Your Ref :
Our Ref : LU/406/17/NMA

Non-Material Amendment following a grant of planning permission LU/310/17/PL for 1 - Change of porch roof to gable fronted, 2 - Omit window on GF, 3 - Move window at FF, 4 - Render GF & porch extension instead of painted brick, 5 - Change bin store to hardstanding & 6 - Extend front garden wall.

93 East Ham Road, Littlehampton, .

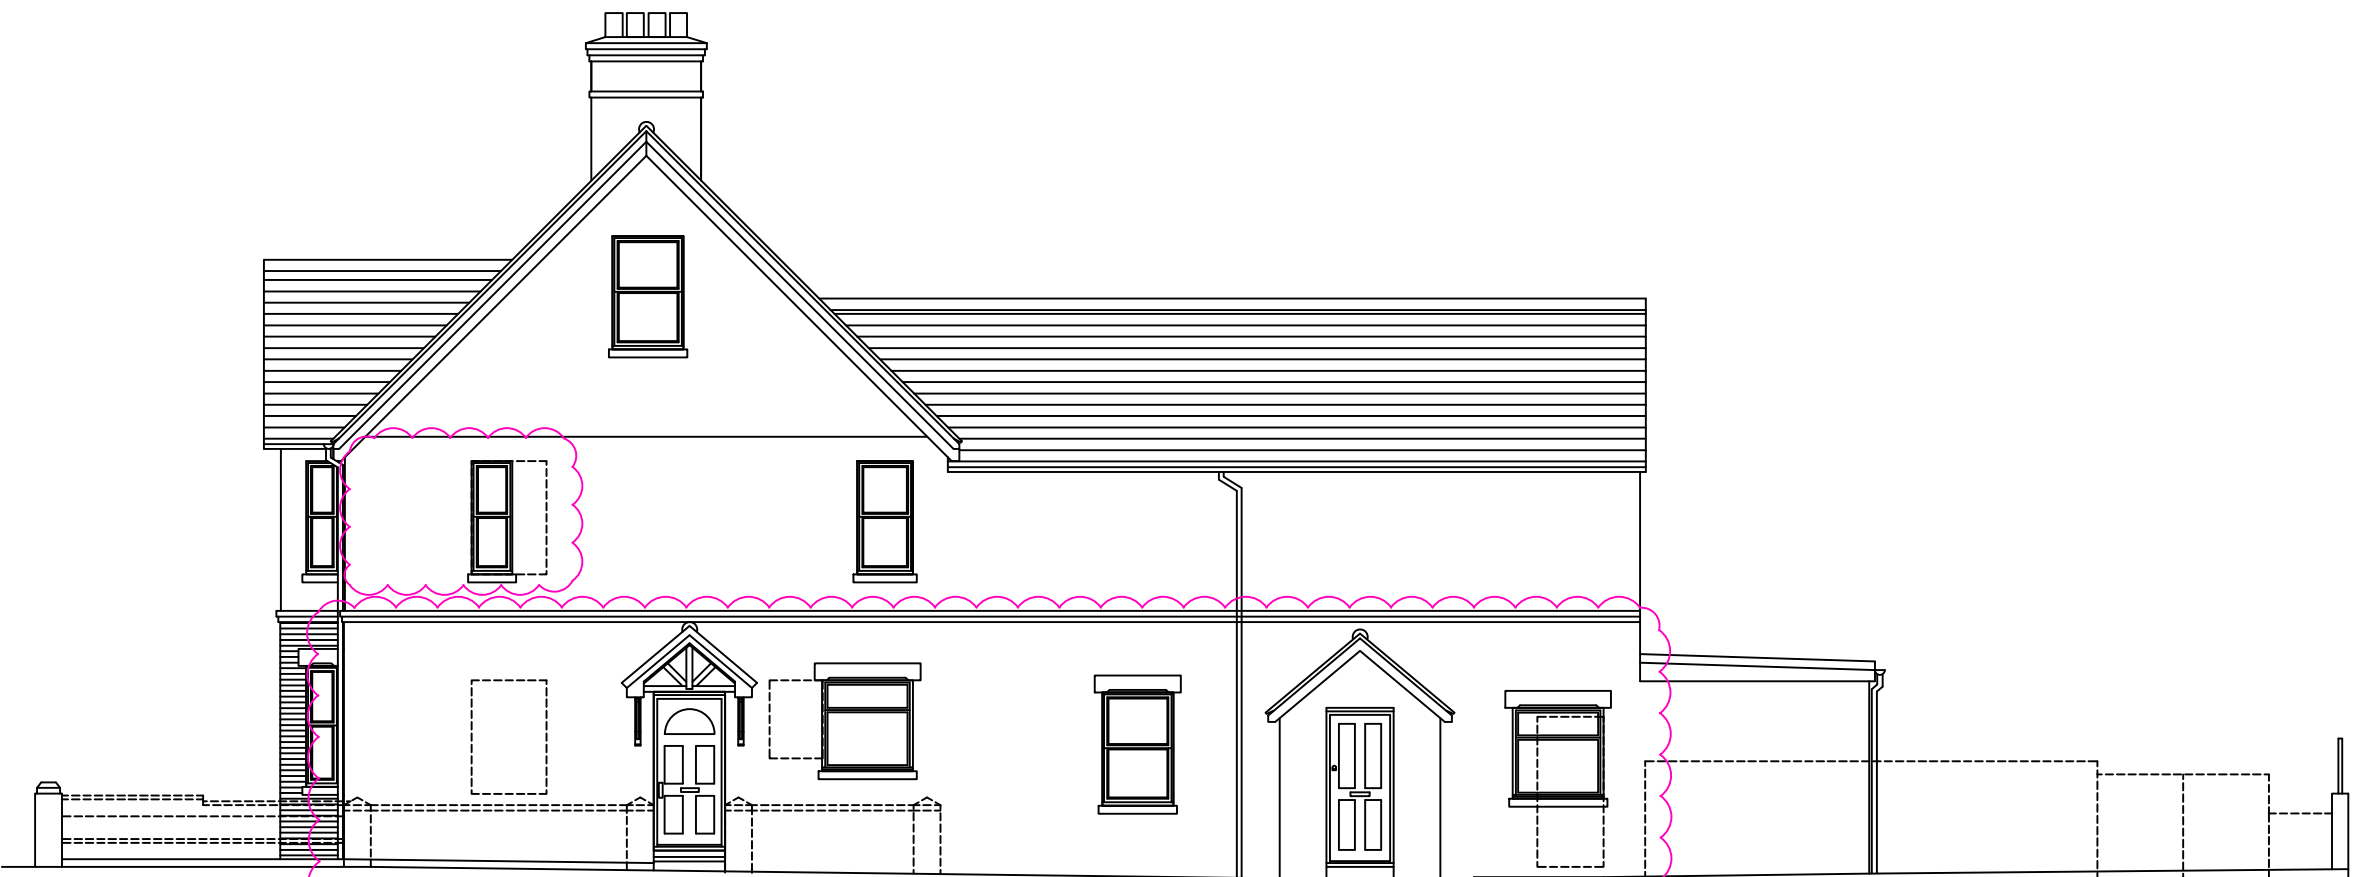
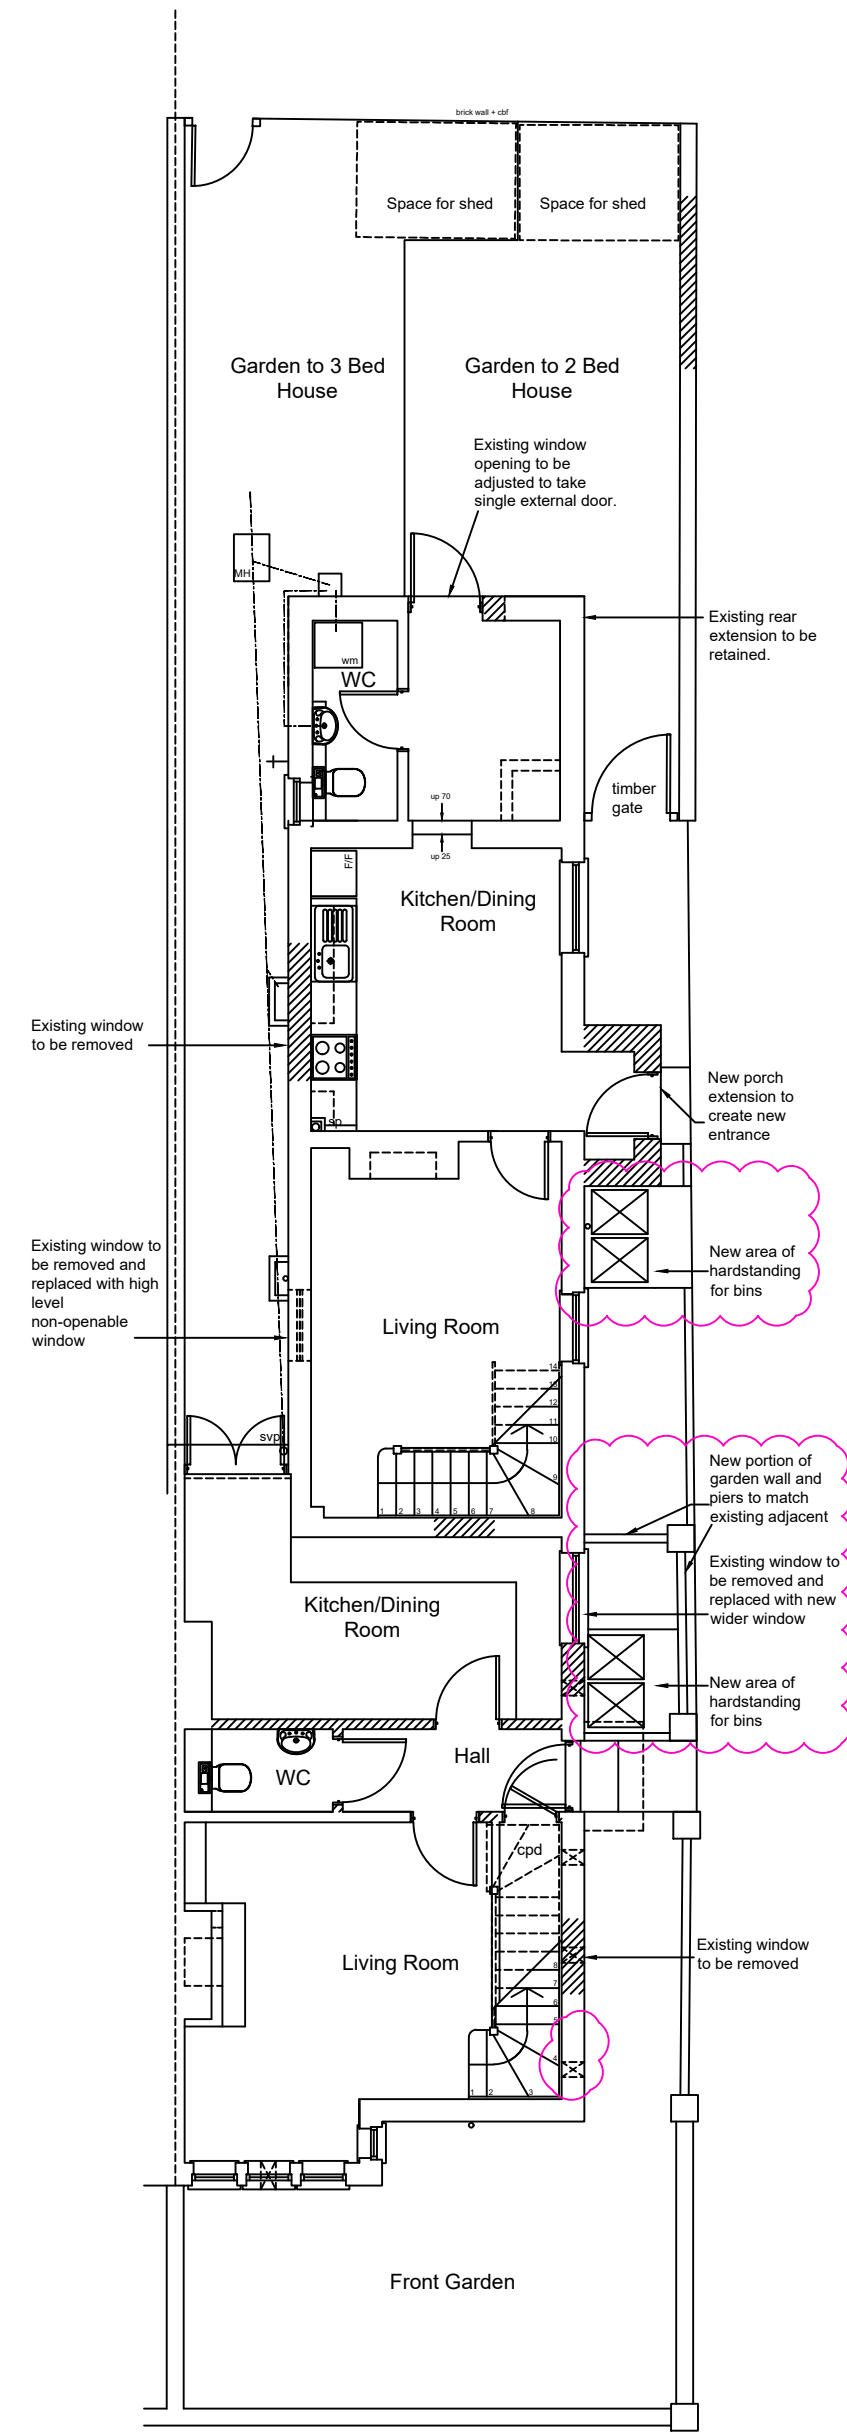
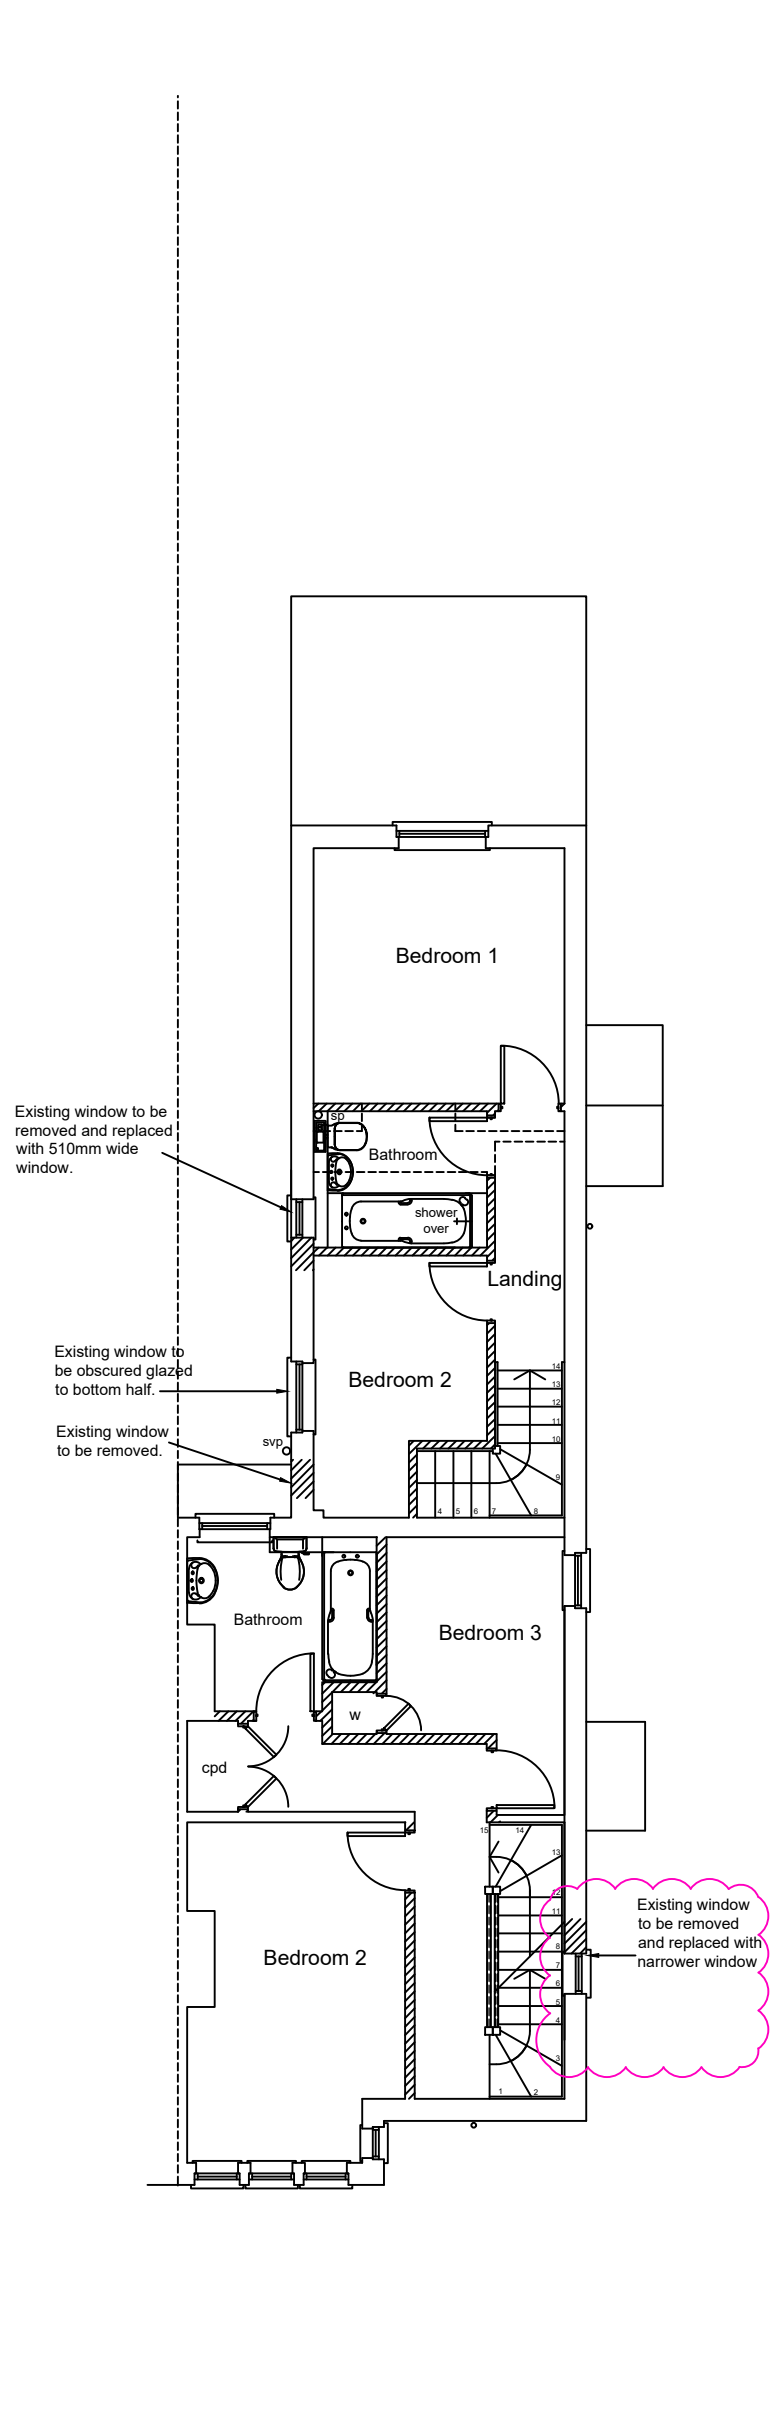
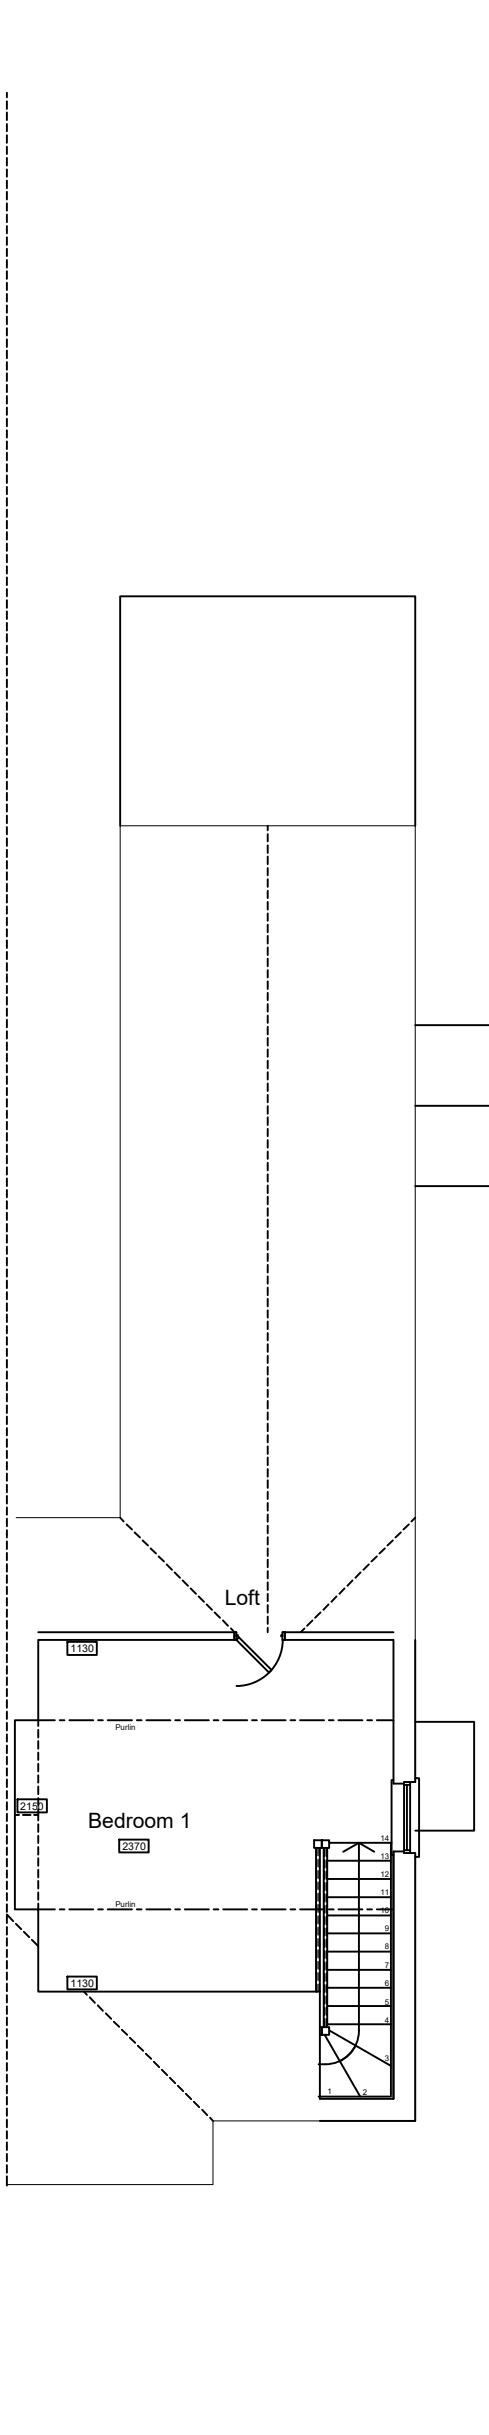
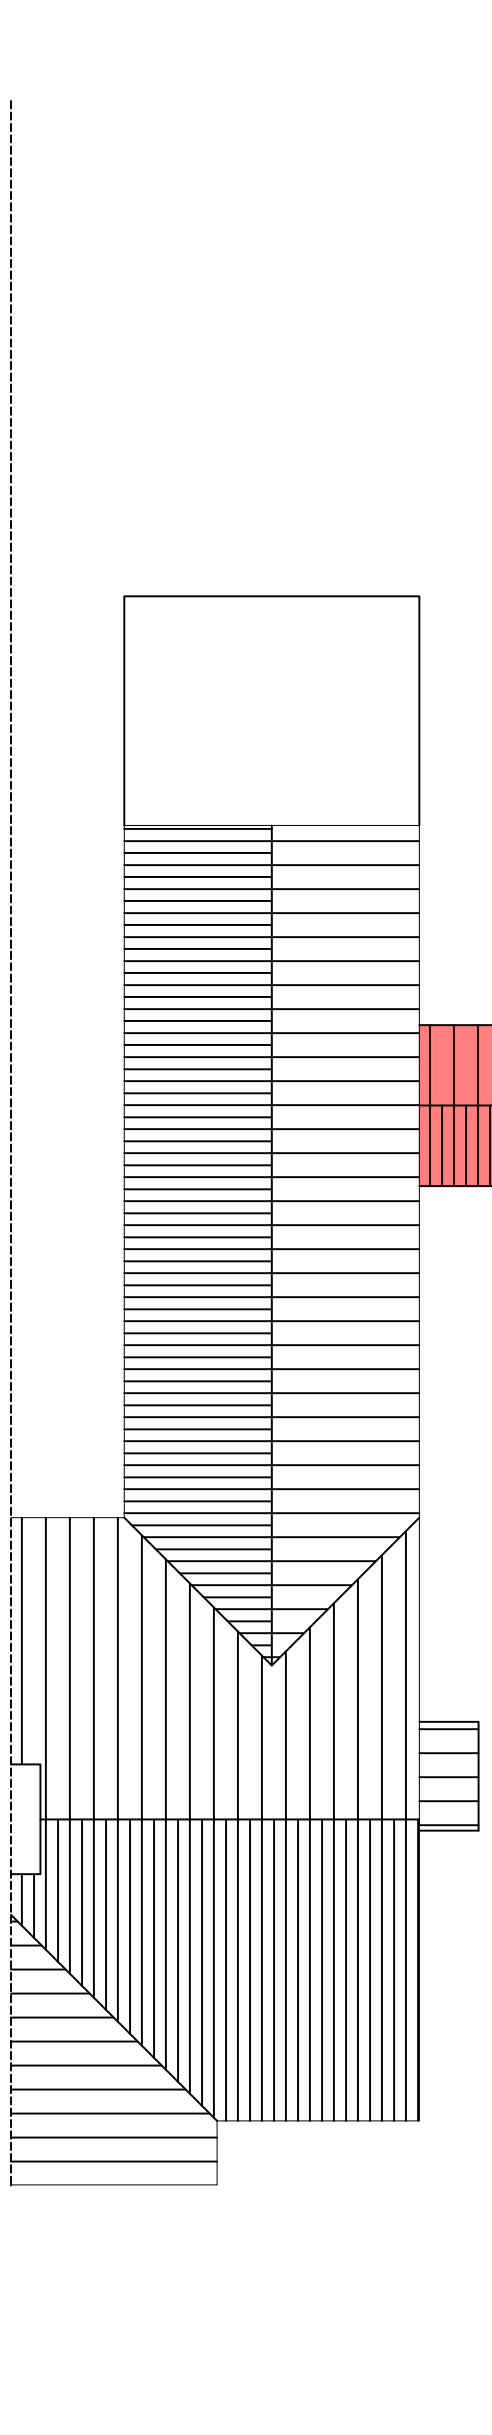
From the information submitted I am able to take the alterations to the building proposed, namely change of porch roof to gable fronted, omit window on GF, move window at FF, render GF & porch extension instead of painted brick, change bin store to hardstanding & extend front garden wall, as a Non Material Minor Amendment to LU/406/17/NMA. Drawing number 0011 03H has now become the approved plans for planning permission LU/310/17/PL.
